Consultation Response from KC Landscape

Application No:	2024/91476
Proposed Development:	Erection of 20 dwellings and 6 quarter houses
Location:	Clough Farm, Long Lane, Earlsheaton, Dewsbury, WF12 8LQ
Applicant/Agent:	eleven52architects
Planning Officer	WS
Date Responded:	05.08.2024
Responding Officer:	Landscape
Responding Ref:	NN33

Plans considered/reviewed: 0389-LON-102,
Outline Landscape Masterplan & Specification PWP 368 002 rev 01
Setting – this layout for 26 dwellings is adjacent to Chickenley Beck & WHNetwork.

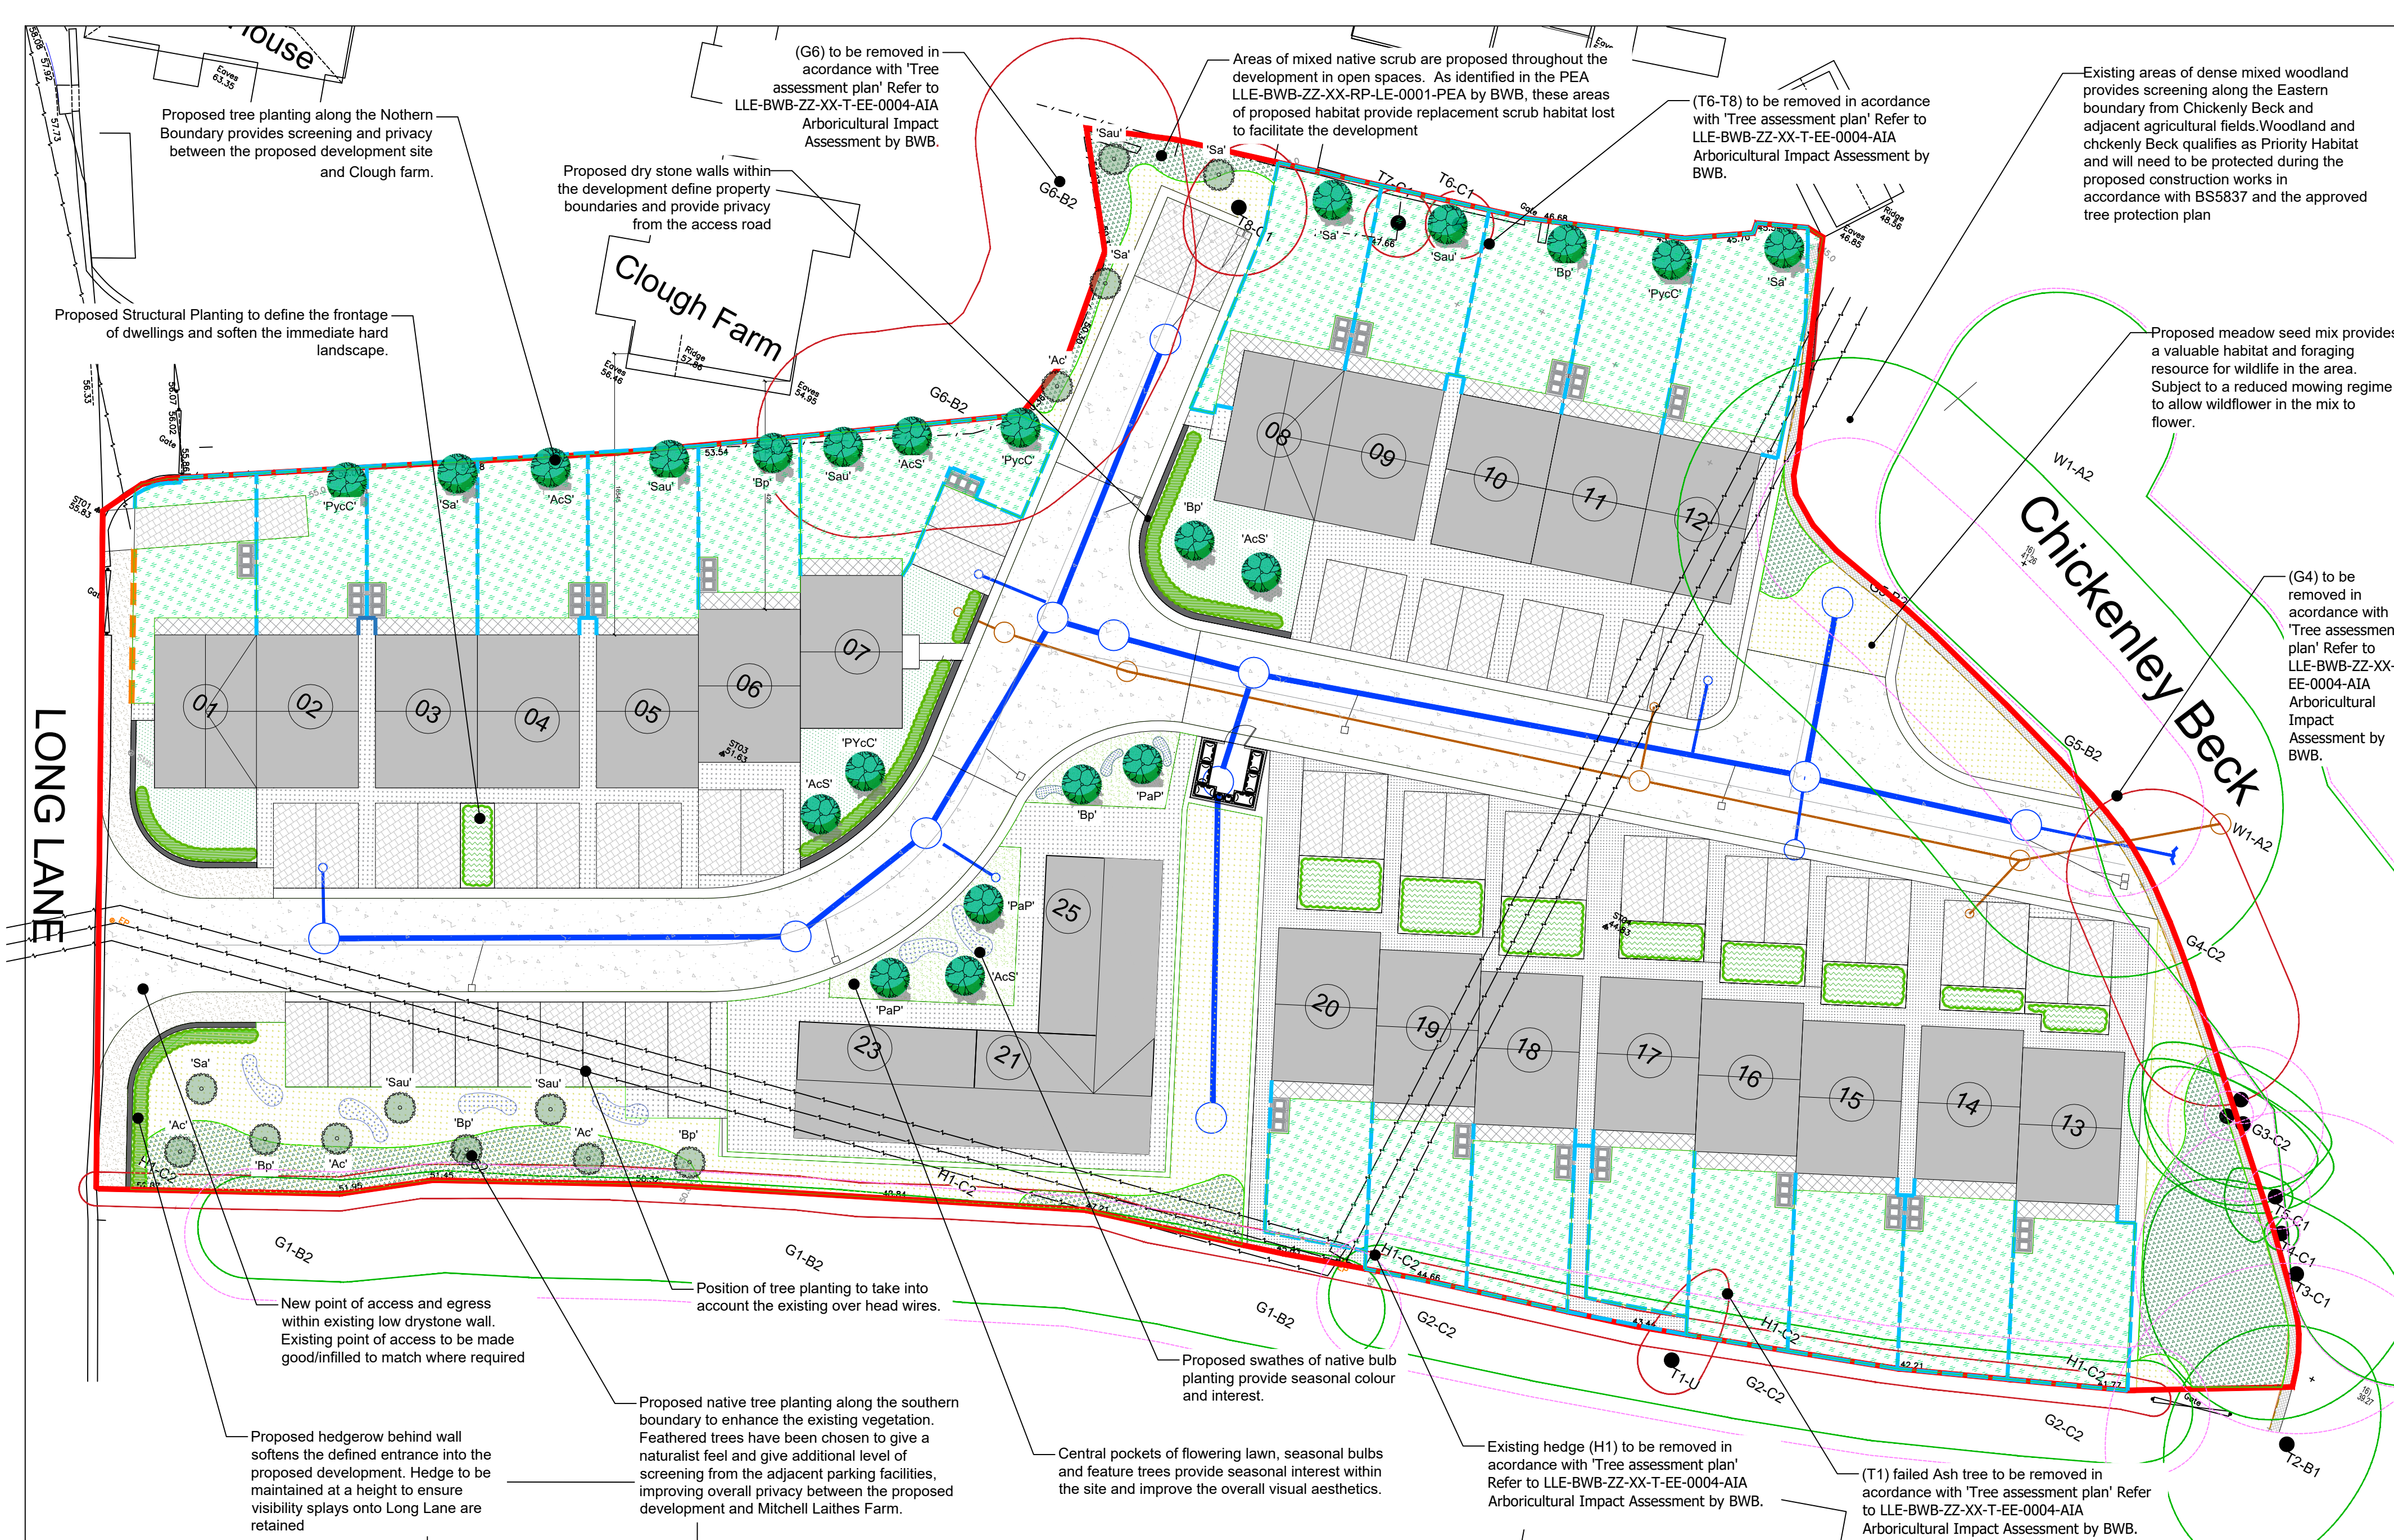
- The plan shows some areas of landscape planting and meadow grass, these are likely highways verges or buffer and screen planting to meet the requirements of BNG rather than open space for use by the public as per LP63.
- To ensure establishment of the proposed landscape scheme, maintenance and management plans should include a 5 year plan for replacement, however the landscape plan indicates only the 1 year maintenance period.

9. The plans submitted /landscaping/ scheme documents do not appear to have taken into account street tree planting of the estate roads. We understand the space is limited, however the NPPF is clear. Trees in rear or private gardens cannot provide the same public amenity and tend to be removed before they reach a size that allows them to contribute to the setting of the development.

14. Additionally, we would anticipate all new tree planting within 5m of the adoptable highway to include adequate root barrier, clearly identified on the proposed landscape plans.

18. The landscaping proposals submitted along with the planning application, are welcomed however the shrub planting list includes some potentially invasive species, which should not be planted in this setting given the greenbelt locality and should be substituted with more appropriate less invasive species. Cornus alba is in the urgent ranked taxa and should be substituted by a species less invasive, and not on the Natural England list.

21. The remaining landscaping scheme is acceptable. However, it doesn't look like any management plan for the scheme has been submitted. The plans should provide details of planting and maintenance requirements for the trees and planting to meet our expectations.

41. S106 required for off site lump sum – see suggested clauses below
42. Please show drainage infrastructure on the landscaping plans, to demonstrate no conflict between proposed landscape proposals, new and existing trees and drainage.
